5th August 2018

CATHERINE McAULEY CATHOLIC COLLEGE, 507 Medowie Rd, Medowie
(SSD 8989)

The Government Architect NSW has been asked to provide independent design review commentary on State Significant Development application SSD 8989. Please find our response below.

Figure 22: Site Vehicular site access and parking arrangement

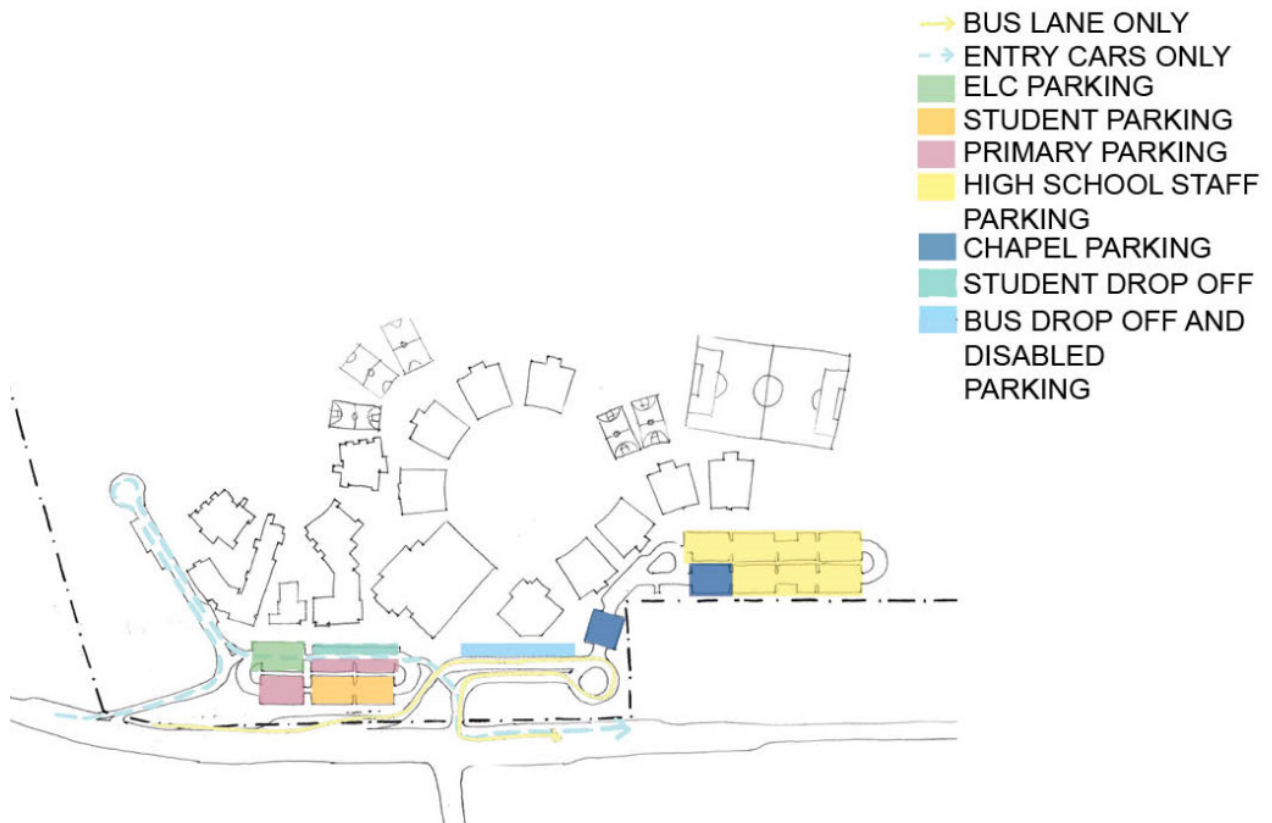
The extent and configuration of car parking has a significant impact on the proposal, particularly in terms of pedestrian amenity / safety and campus identity / presentation. This has been a key issue since the preliminary review sessions with GANSW. While some improvements were made during the review period – between meetings one and two, this issue has not yet been adequately addressed.

Provisions for car parking seem excessive. There are 272 formal spaces (44 more than required by the Port Stephens DCP) with an additional 50 informal spaces as well as 12 on site bus bays which will be used for car parking outside key bus drop off/ pick up times. The combined impact of these, together with a complex internal road system, creates an extensive asphalt terrain that dominates the campus frontage.

4. Review parking provision, including justification for visitor and overflow parking.
5. Review parking configuration to reduce impact of the parking areas at the main school entry. Consideration could be given to distributing parking to other less prominent locations on the campus. (GANSW review 27.02.2018)

Figure 23: Pedestrian Site Access Diagram

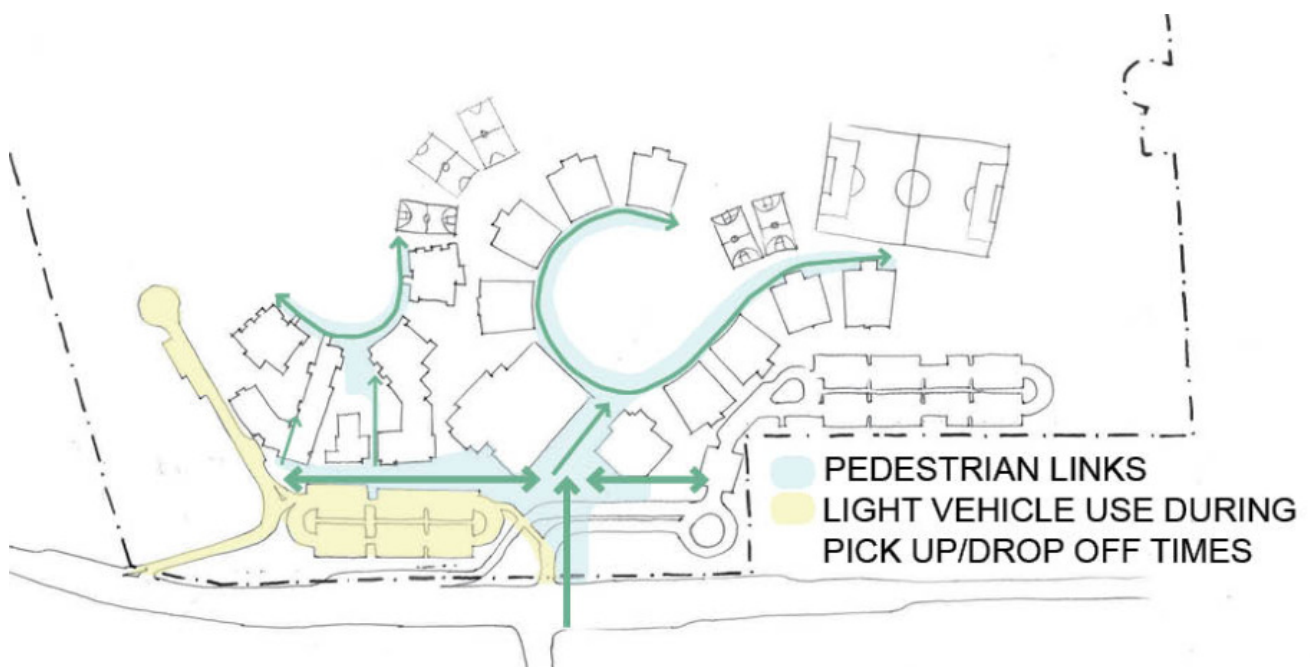
There appears to be little provision for pedestrian access to the campus, with no footpaths shown on the proposed Medowie Rd / South St intersection upgrade.
